WELWYN HATFIELD COUNCIL
PLANNING CONTROL COMMITTEE – 25 SEPTEMBER 2008
REPORT OF THE CHIEF PLANNING AND ENVIRONMENTAL HEALTH OFFICER

S6/2008/0690/FP

ST AUDREY'S CAR PARK, CHURCH LANE, HATFIELD, AL9 5NB

IMPROVED ENTRANCE TO HATFIELD PARK FOR COACHES AND HGV'S,
WIDENING THE ACCESS FROM CHURCH LANE, FORMATION OF COACH
PARKING AREA, CIRCULATION TRACKWAY AND ALL ANCILLARY WORKS

CLIENT:	THE CASPIAN CENTRAL ENTRIES
JOB:	ST AUDREY'S ENTRANCE
DATE:	MAR 2008
SCALE:	1:500
DRAWING TITLE:	PROPOSED SITE PLAN
DRAWING NUMBER:	757-002 E

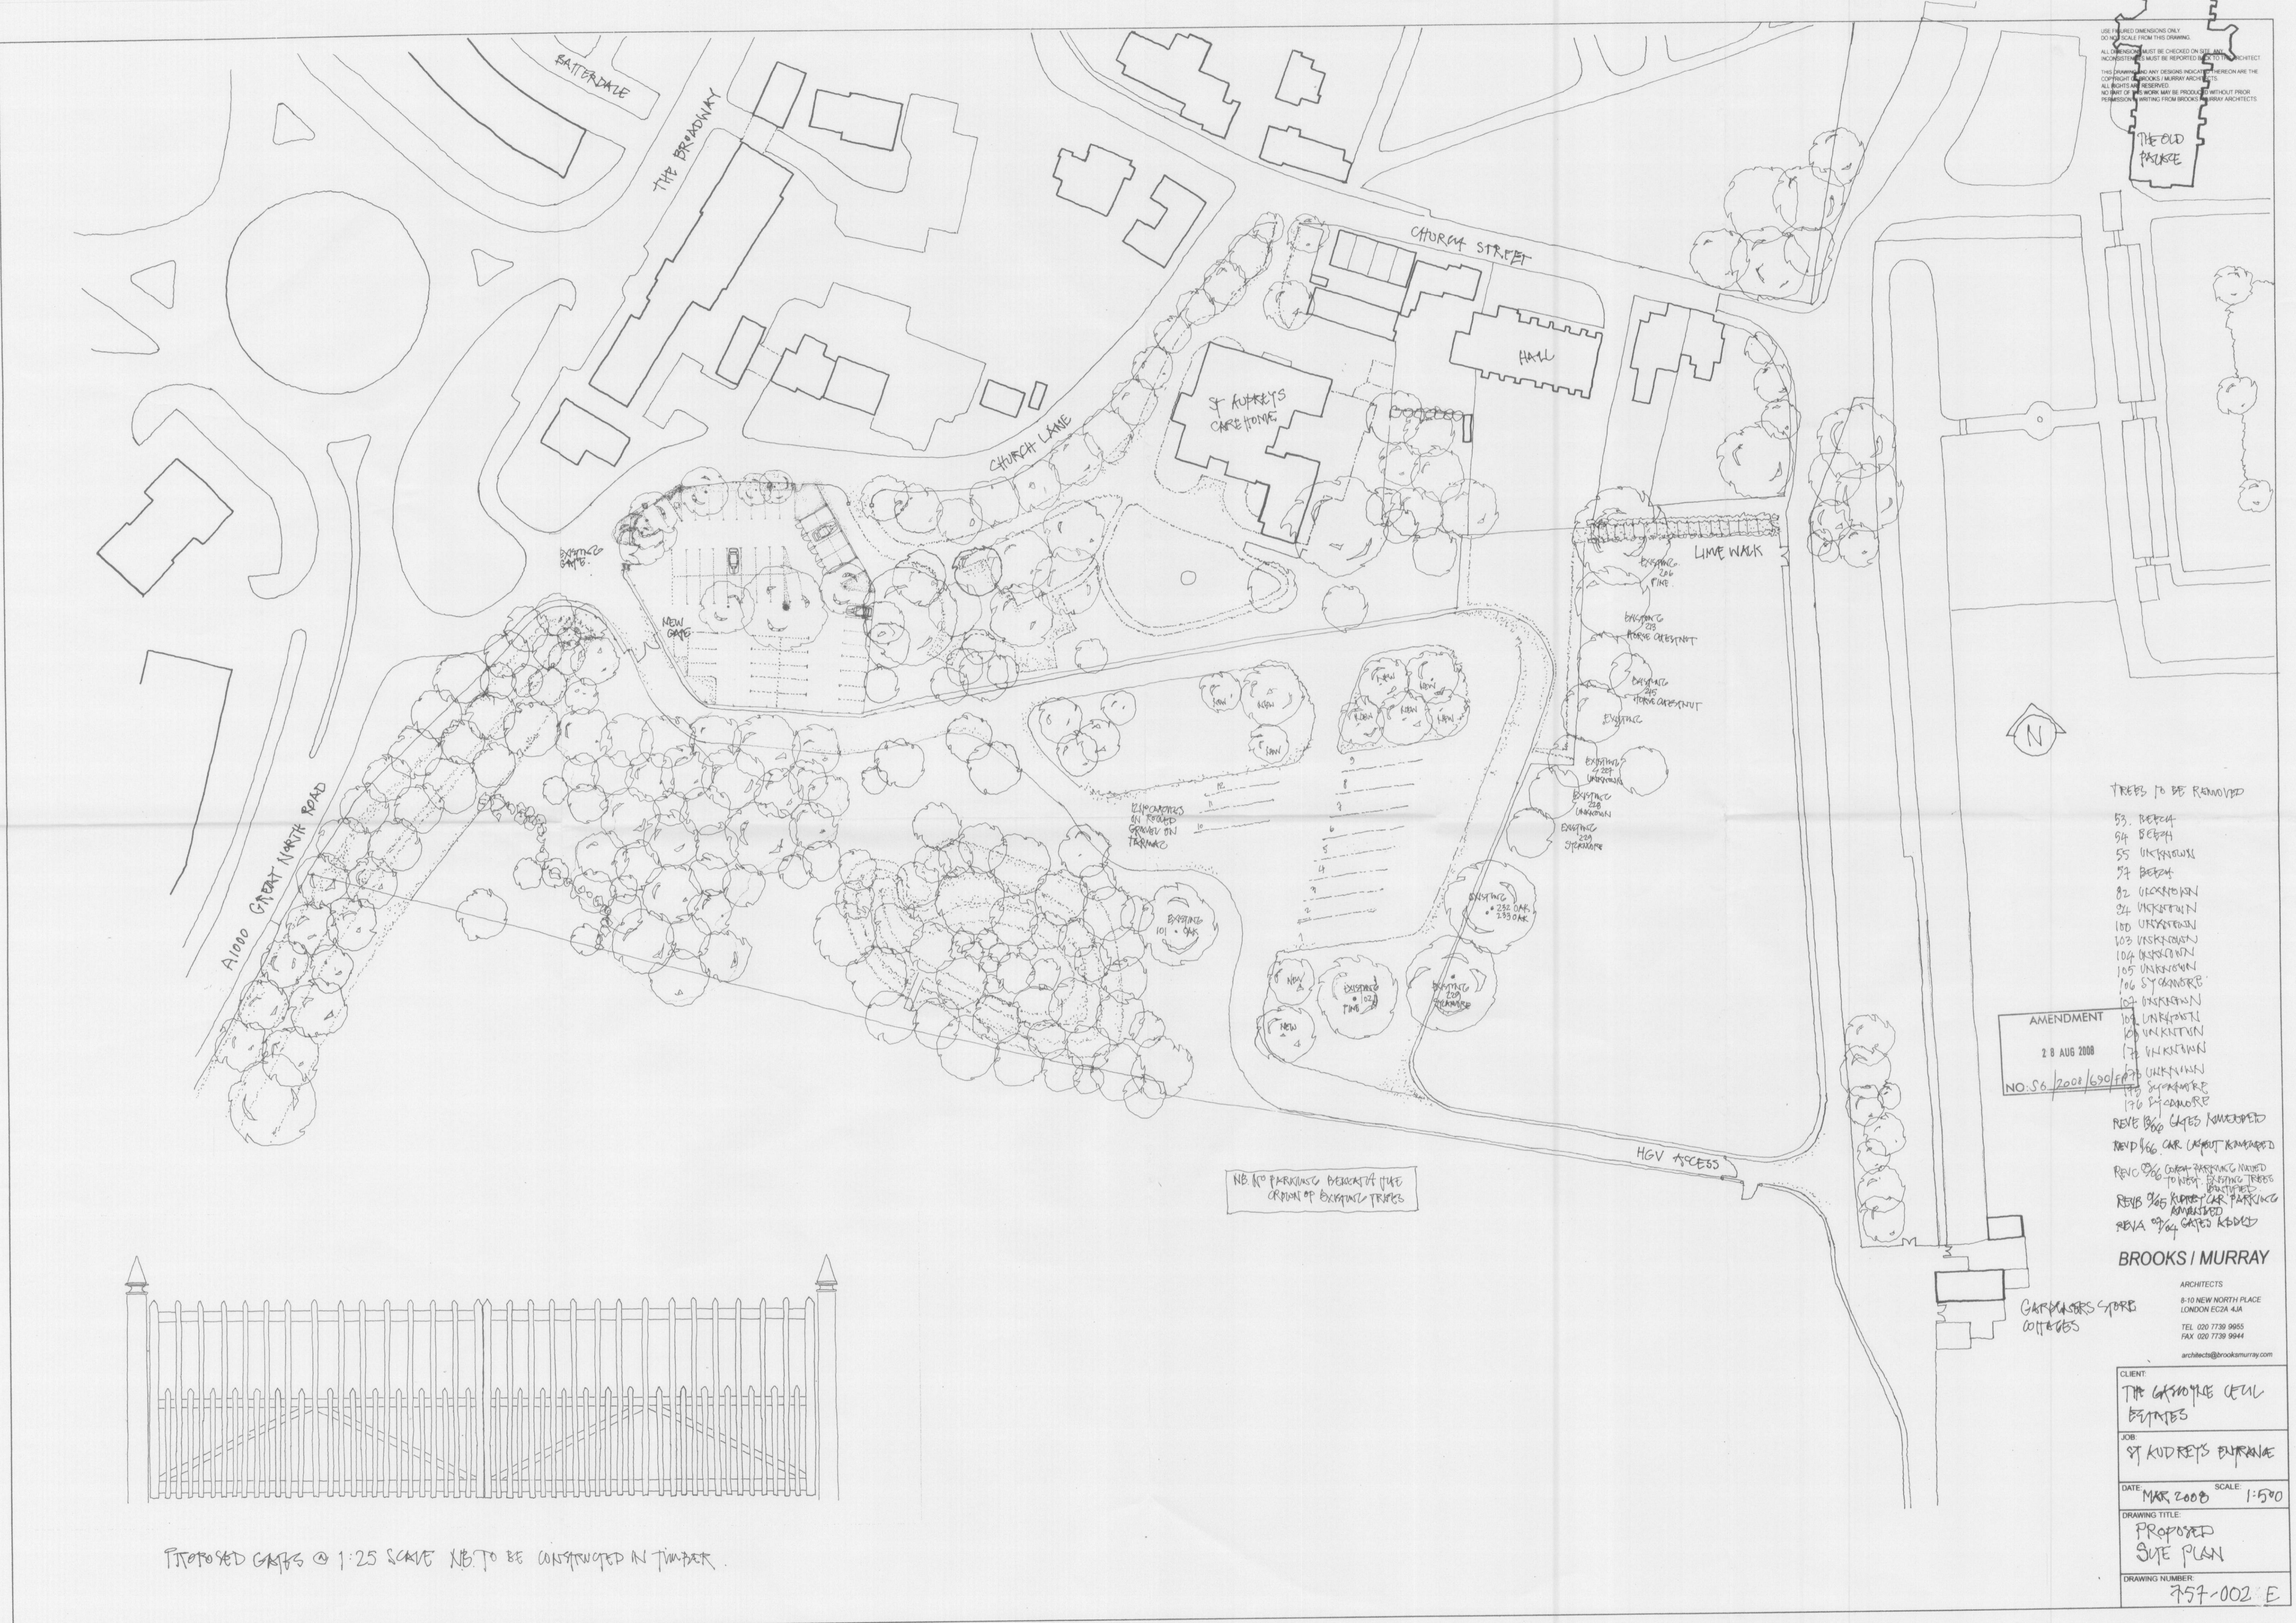
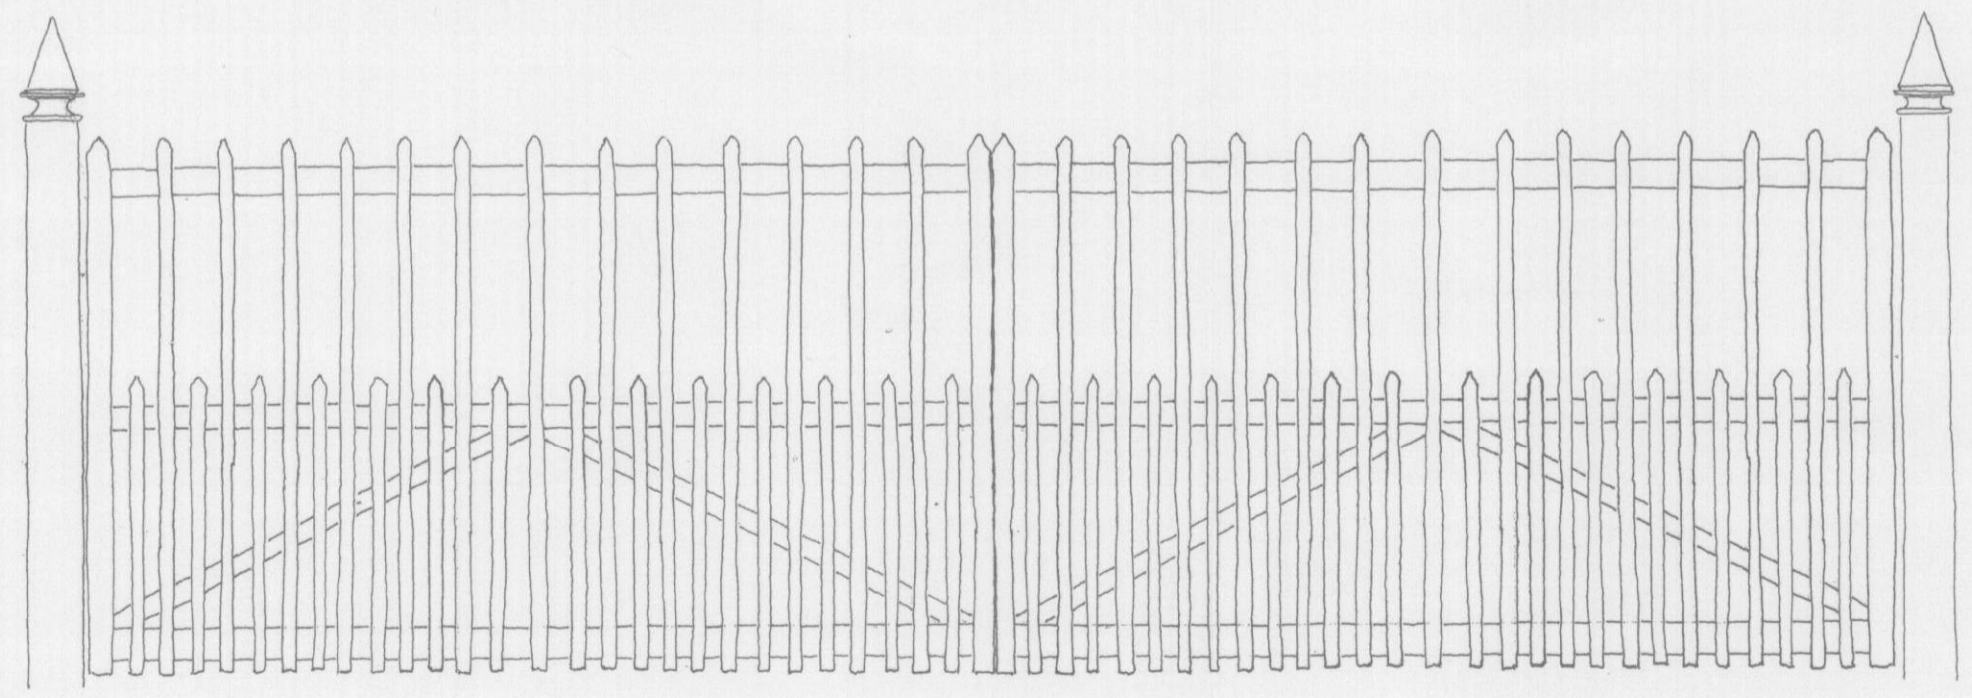
- 3.4 The parking area would be secured by a new access gate set back by approximately 20 metres from the back edge of the highway. This would have a maximum pillar height of 2.25 metres with the main gate measuring 1.7 metres high. Details have not been submitted regarding the proposed materials.

- 6.4 **Landscaping Section** – Had strong objections to the original layout of the scheme and considered that it would have a significant detrimental impact upon the health of a number of trees within the surrounding area.

- 6.5 The new layout has been negotiated, which is more sympathetic to the trees on the site, with hard standings a reasonable distance from the trees and no parking beneath the crowns of existing trees.

- 9.52 The gate has a simple open design which would be reflective of the more rural aspect of this particular area. Details have not been submitted regarding the proposed materials for the gate, however it is anticipated that it would be finished in either timber or metal which would complement the locality. A condition is therefore suggested for submission of materials for the gate and the proposal would therefore comply with policies D1 and D2 of the local plan.

5. Prior to the commencement of the development hereby permitted, details of the materials proposed for the gated entrance shall be submitted to the Local Planning Authority for approval in writing. The approved details shall subsequently be implemented in accordance with the approved details as shown on drawing number 757 002 E received and dated 28th August 2008.

18. Between the hours of 2130 and midnight coaches shall be parked in spaces labelled 1 – 4 as shown on drawing number 757-002 E dated 28 August 2008 and in no other part of the site.
